Recommendation Report for Planning Permission for Works or Extension to a Dwelling

REF NO: AW/161/19/HH

LOCATION: 106 Rose Green Road
Aldwick
PO21 3EF

PROPOSAL: Dormer roof extension. This application may affect the setting of a Listed Building.

- REV DATE AMENDMENT BY	
PROJECT 106 ROSE GREEN ROAD ROSE GREEN. SUSSEX. PO21 3EF	
DRAWING PROPOSED PLANS	
Date May 2019	Drawn By PJC
Scale 1: 100 @A3	Iss. App. By DKC
Drawing No 003	File Location 0313

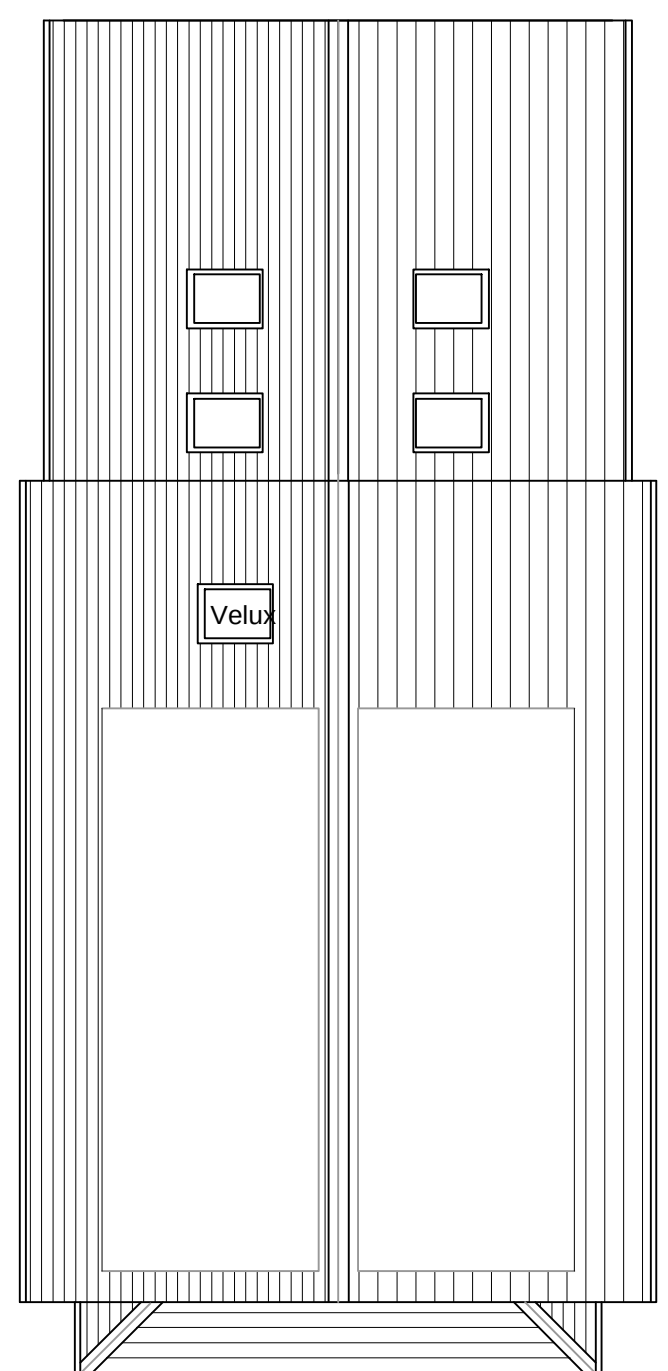
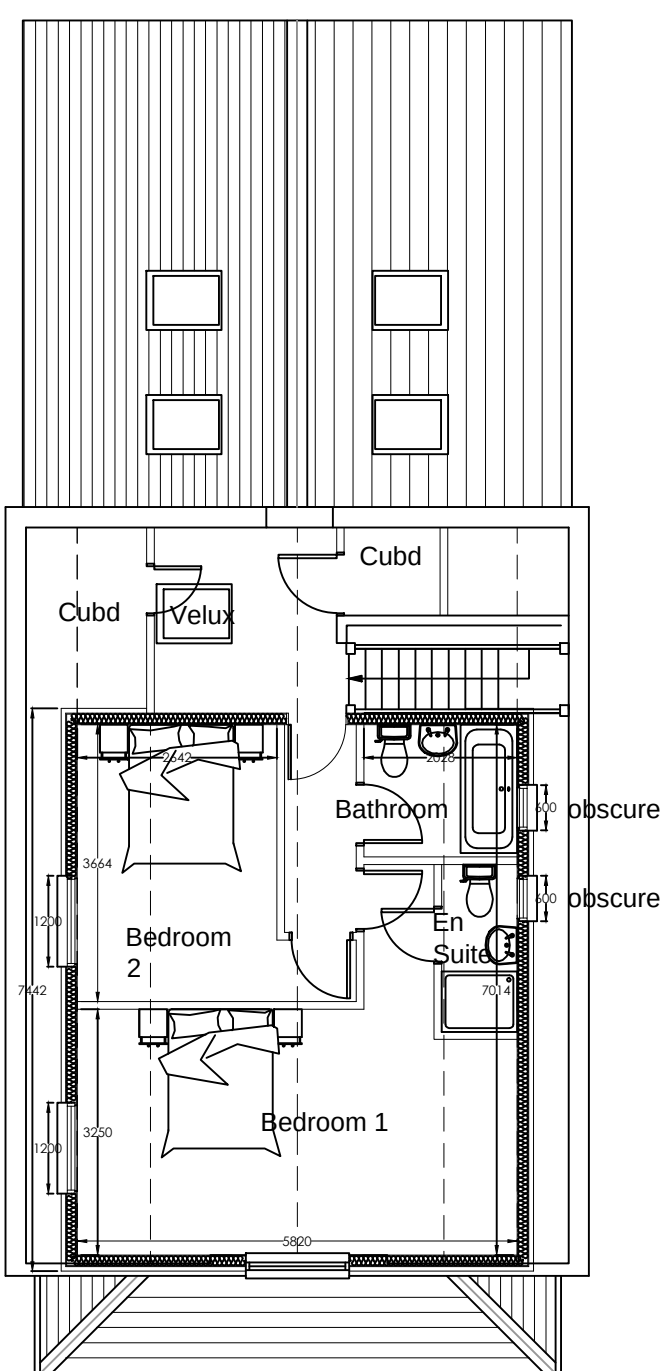
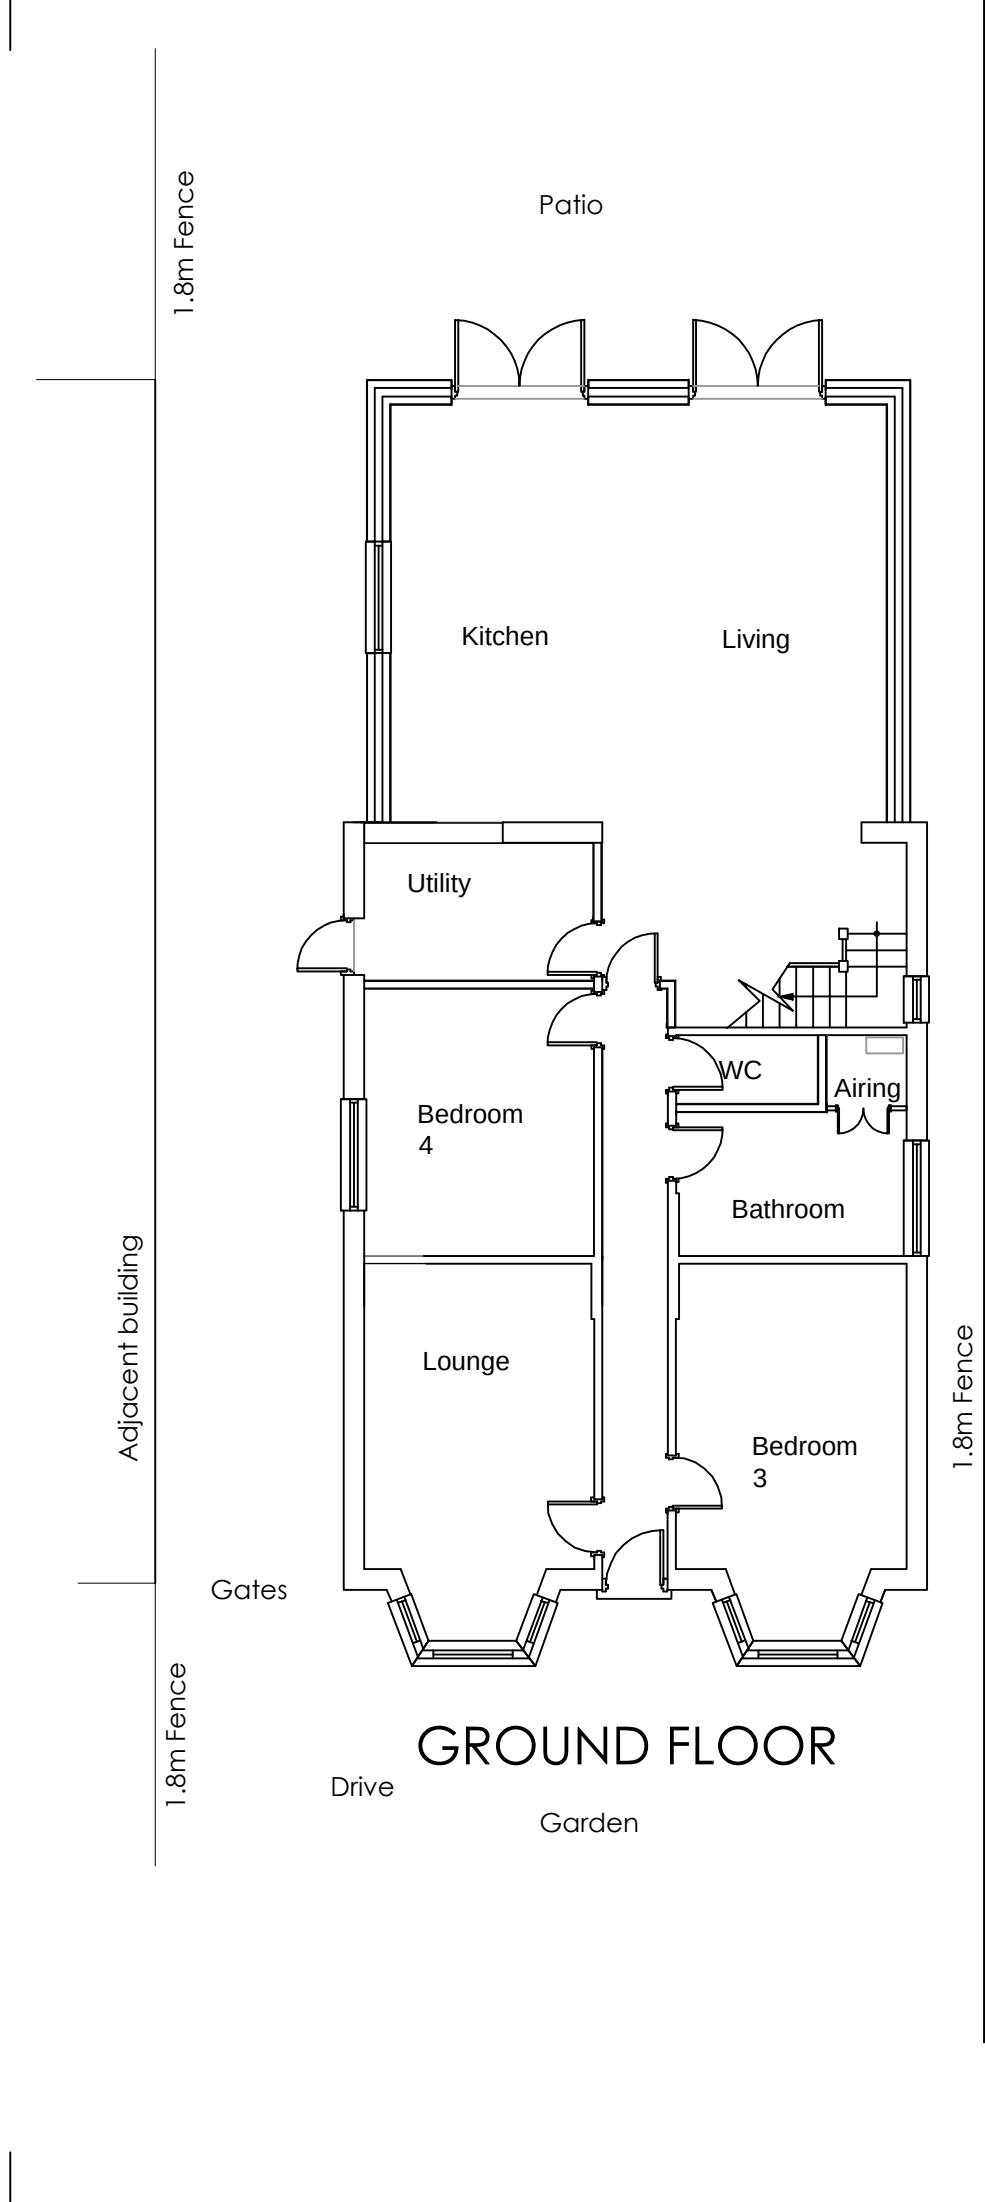
There will be 2 obscured windows as shown on the plan serving bathrooms to the east and as such are not considered to give rise to any adverse overlooking upon neighbours to this elevation.

DRAWING
PROPOSED
ELEVATIONS

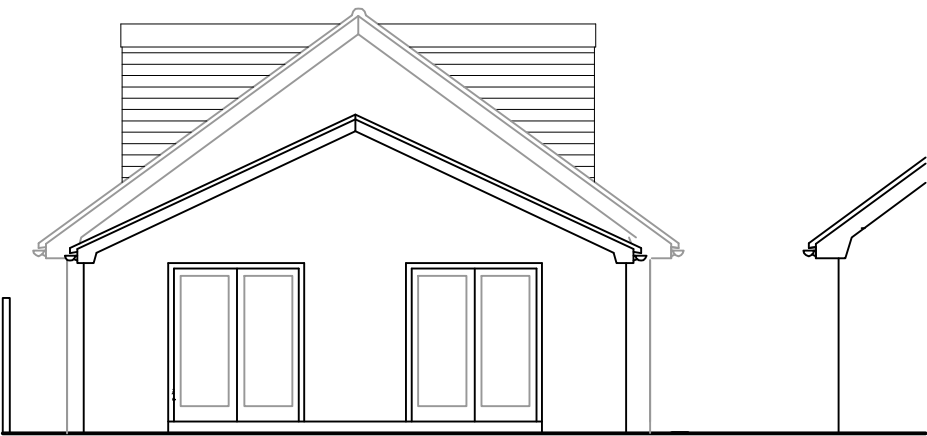
The dormers will sit to the side elevations running along the roof at a length of 7.4m however does not extend the full roof depth. The dormers will have a depth of 2.85m and a height of 2m retaining around 1.35m to the eaves. With the dormers set back from the eaves the development is not considered to appear overbearing or overshadowing upon neighbouring occupiers.

To the west there will be 2 additional windows serving bedrooms and a velux to the rear roof slope. The property at No.108 has a velux to the roof slope however due to the siting it is not considered the dormer windows would result in significant overlooking upon neighbouring occupiers.

- 3 The first floor windows on the east elevation of the dormer shall at all times be glazed with obscured glass and only openable at a high level, at least 1.7m above finished floor level.
